Our Ref: BR/233/19/PL

Development Part change of use of ground floor & formation of a first floor rear extension to create 2 No self-contained studio flats with associated refuse/ recycling & cycle store (resubmission following BR/63/18/PL).

Location 77 Aldwick Road Bognor Regis

Component: **Elevation of New Gate**

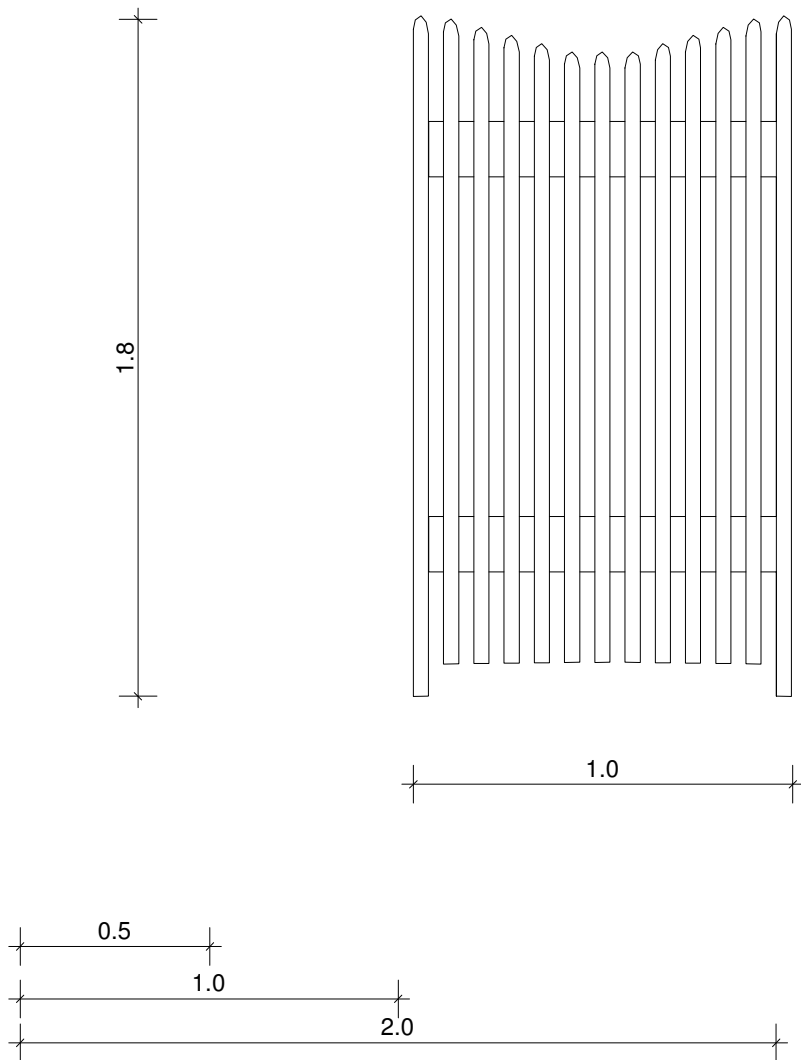
Please provide an elevation of the new gate.
